Comments for Planning Application 23/02728/FUL

Application Number: 23/02728/FUL

Address: Plot 5 Earnley Gardens Almodington Lane Almodington Earnley Chichester West Sussex PO20 7JR

Proposal: Two storey side and rear extensions and single storey rear extensions to plot 5.

**1. Existing Site Layout Plan**  
scale 1: 500

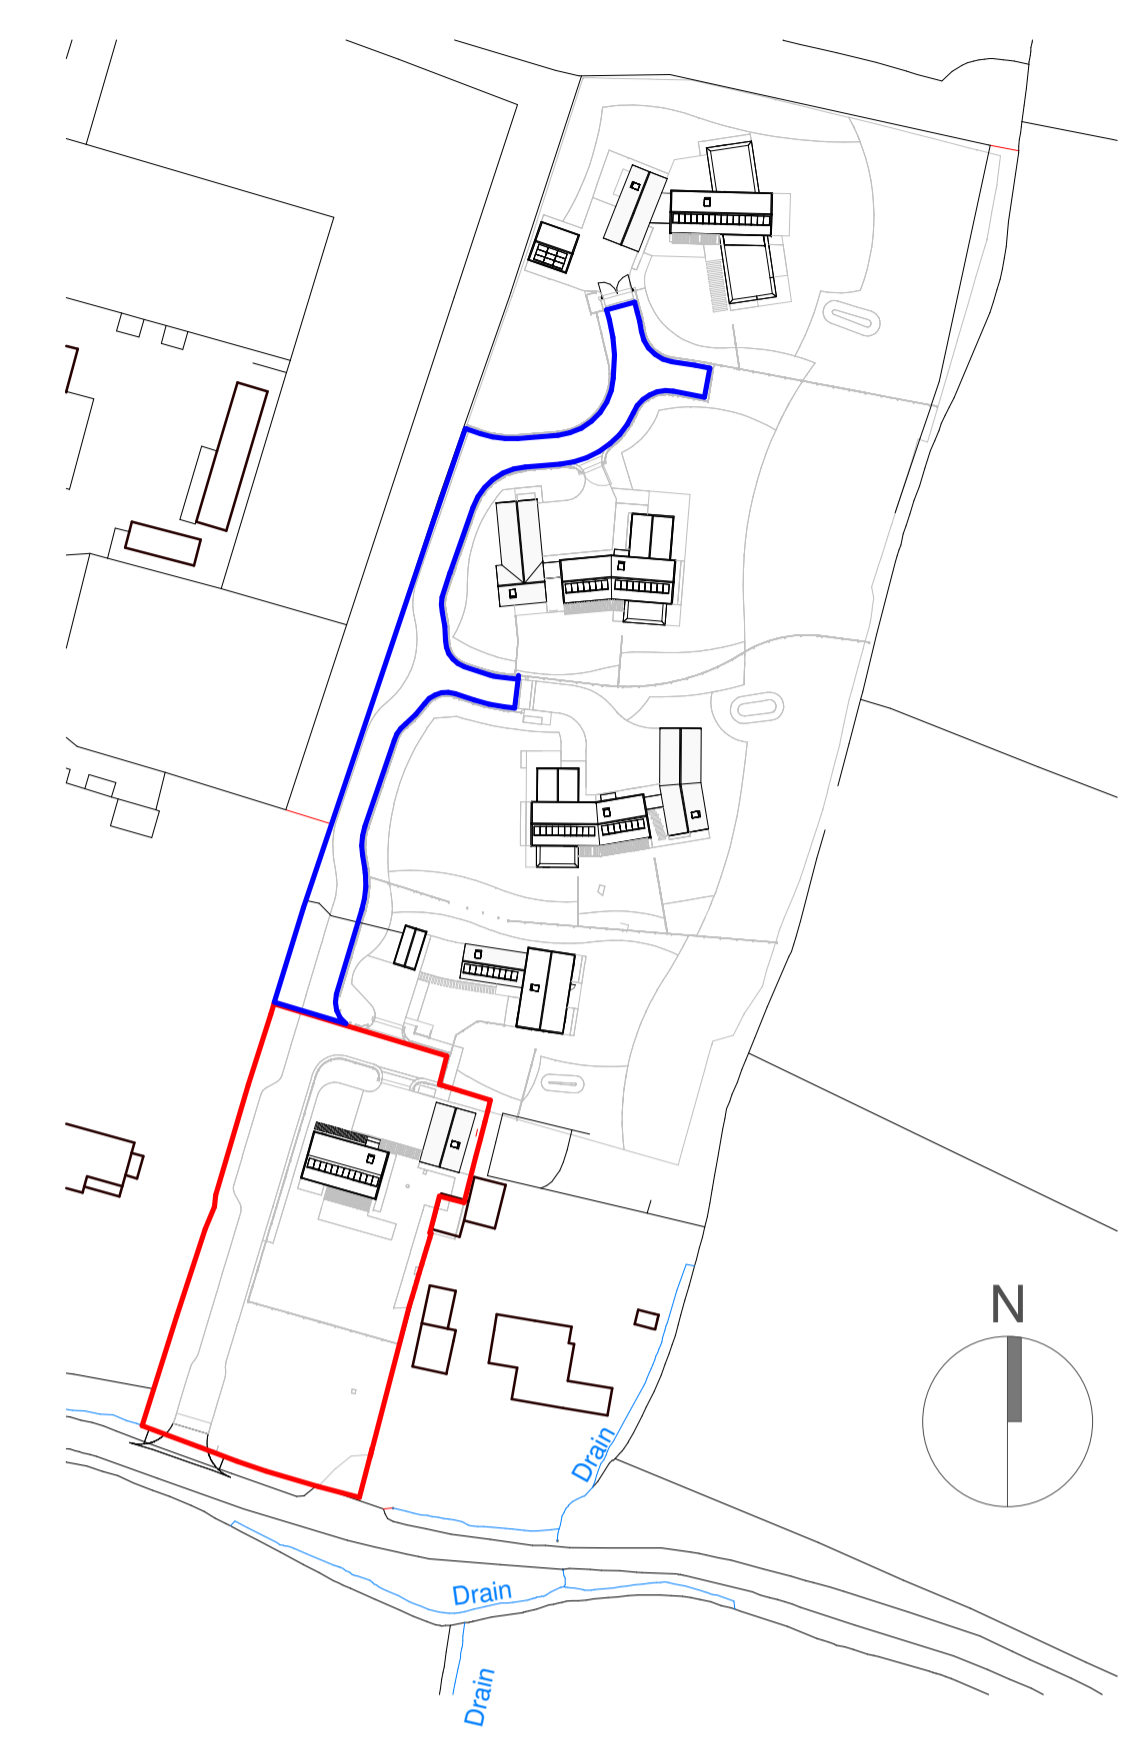
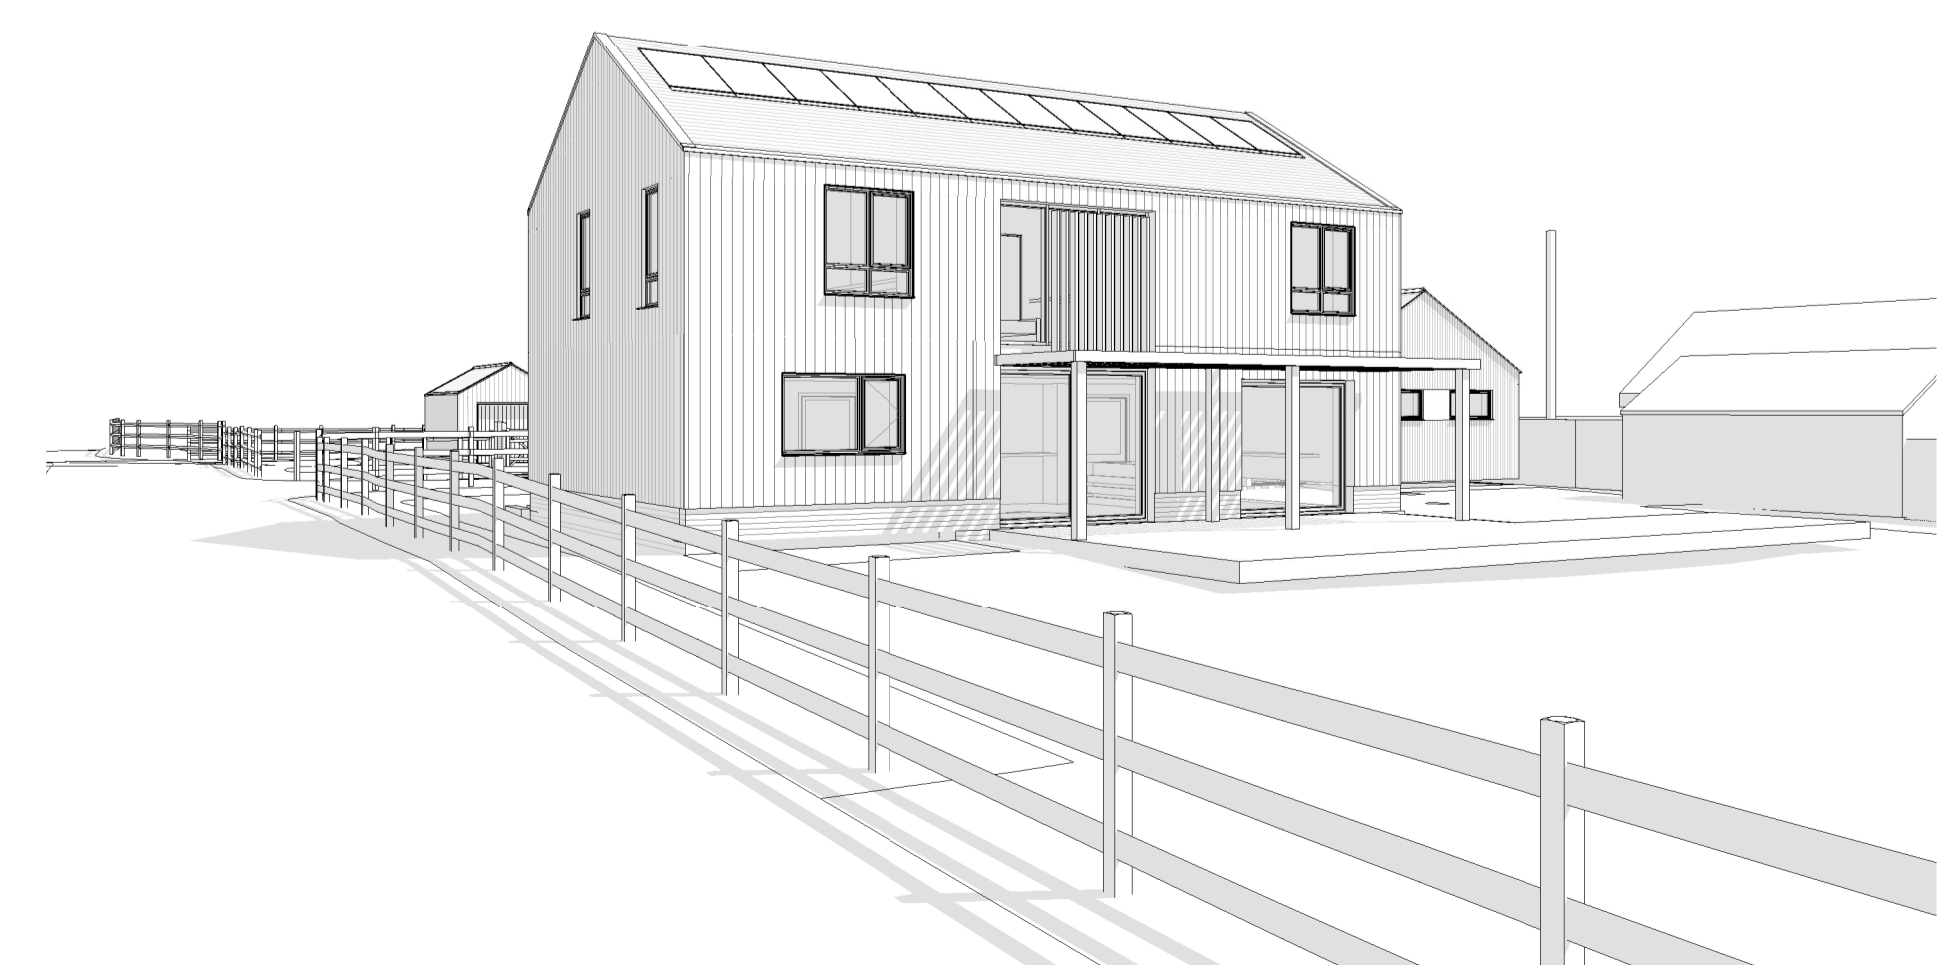
Comment: The map outline of this application which is showing an area marked in red as belonging to the property at 5 Earnley Meadows is incorrect and needs to be amended

The roadway into the Earnley Meadows estate is also to serve as access to houses 1, 2, 3 and 4. It is marked in blue on the planning application

At present, as shown on the submission no access entitlement appears to be granted for houses 1-4, as it is shown blocked by the land belonging to house 5. This is not correct.

While this appears to be a drafting error, it needs amending.
